Application No: M/73/20/HH
Site Address: 60 Southdean Drive Middleton-On-Sea PO22 7TB
Description of works: Replacement art deco style roof accommodation with balcony, removal of chimney breast, fenestration changes, and internal adaptations.

Thank you for your internet representation made on 4th November 2020 which has been recorded as an objection with the comments as follows:

EXISTING/PROPOSED ROOF PROFILE
1:100 @ A3

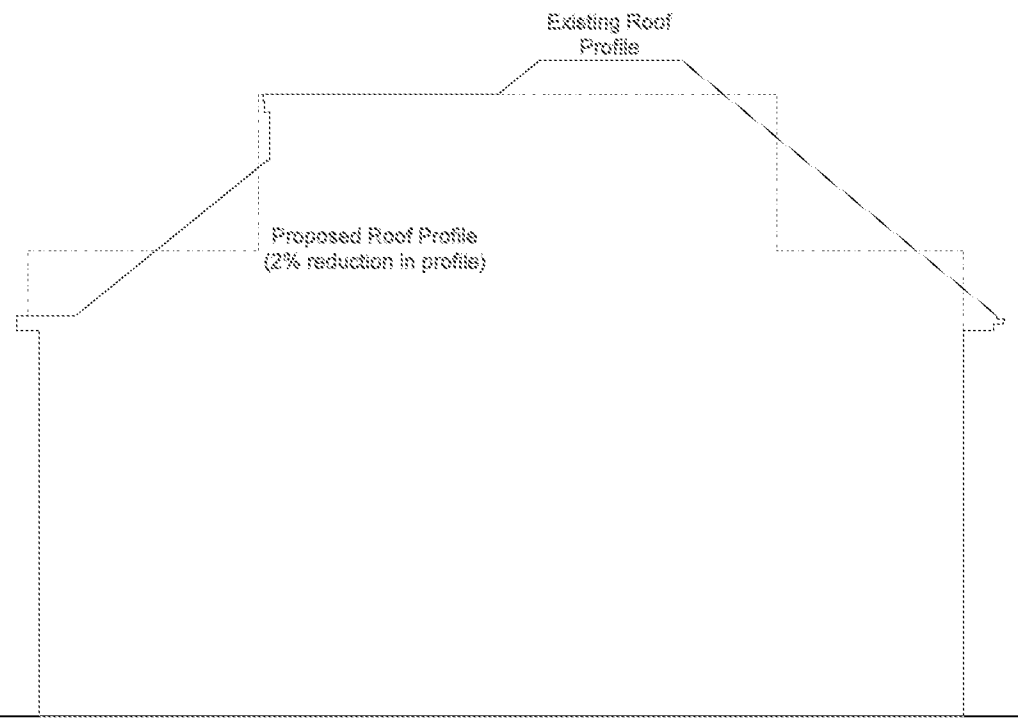
My comments mainly relate to reduced privacy. At present there is no view into our house from the 3rd floor. The construction of a roof balcony appears to give casual line of sight into our rooms. Our rear garden would be totally overlooked, also. It is assumed that FF windows on the eastern side at the rear would remain partially obscured to maintain our privacy. I realise privacy screens would not have been commonplace when the original houses were built or modified. Should the windows be replaced additional obscured glass should be considered to increase our privacy.

The change of profile of the roof and increase in side area of the attic will block more of the natural evening light necessary for the craft study room, making it too dark to work earlier.
